Application no: **3/2021/0254**

Address: **Wellsprings Hotel Clitheroe Road Sabden BB7 9HN**

Proposal: **Proposed extension to create a one bedroom holiday apartment and construction of two single storey one bedroom holiday let units with parking.**

6218 -P01 REV C

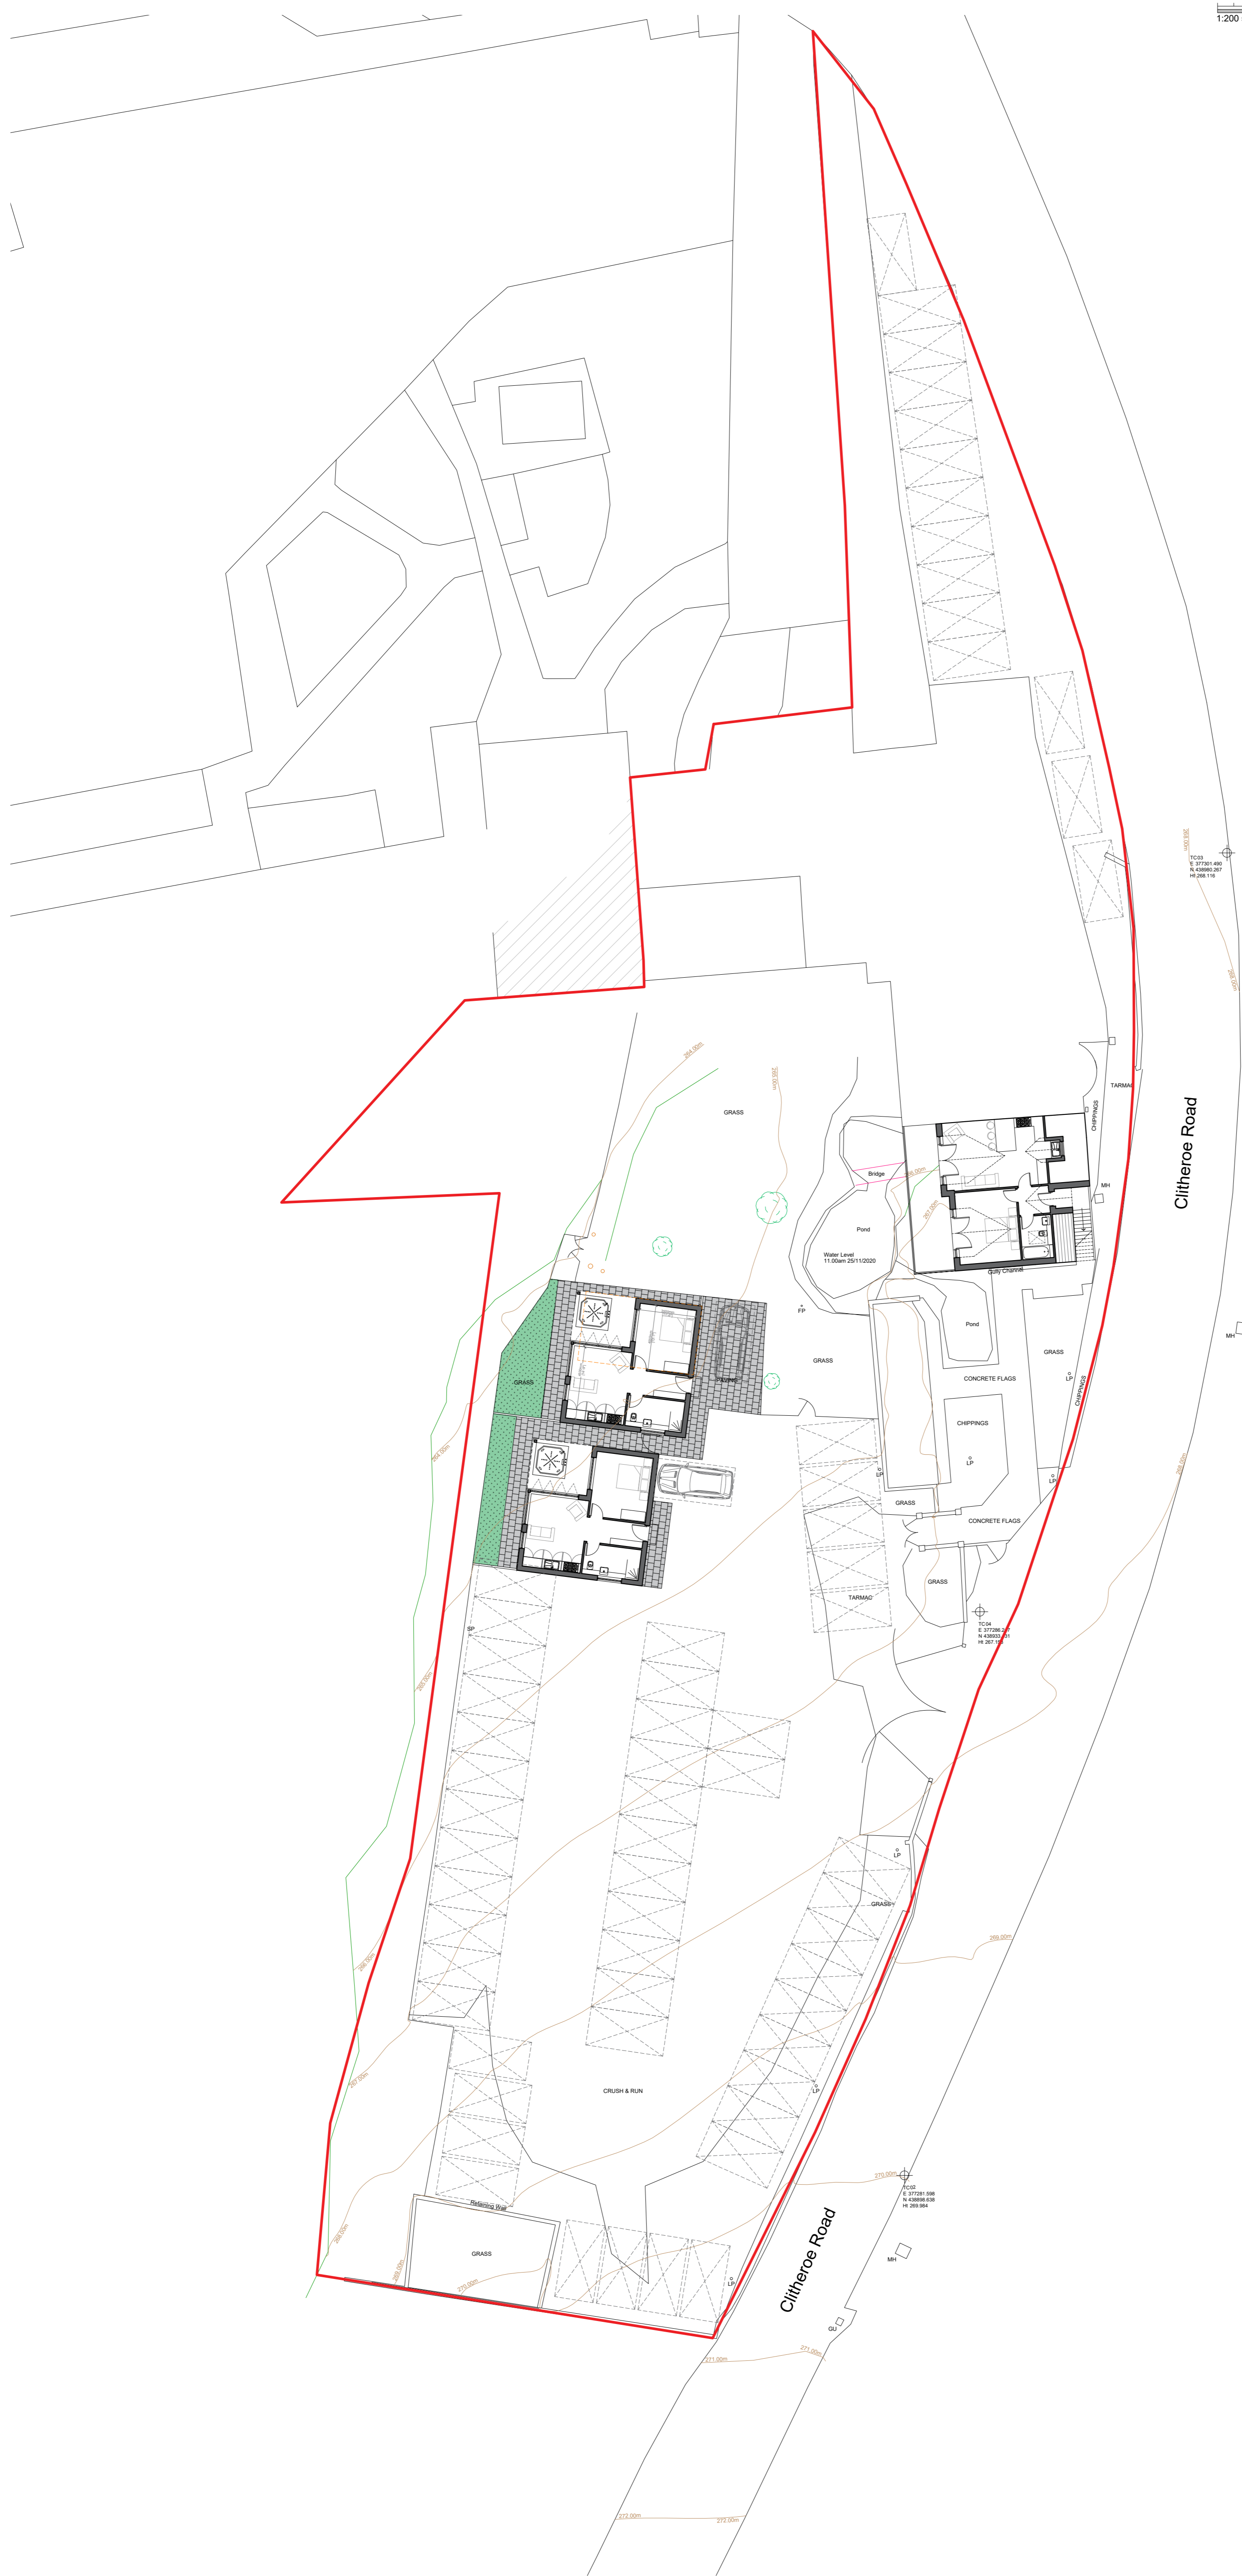
1.The development hereby permitted shall not be occupied until such time as the parking and turning facilities have been implemented in accordance with SPA Proposed Site Plan drawing number 6218 P01 Rev B. Thereafter the onsite parking provision shall be so maintained in perpetuity.
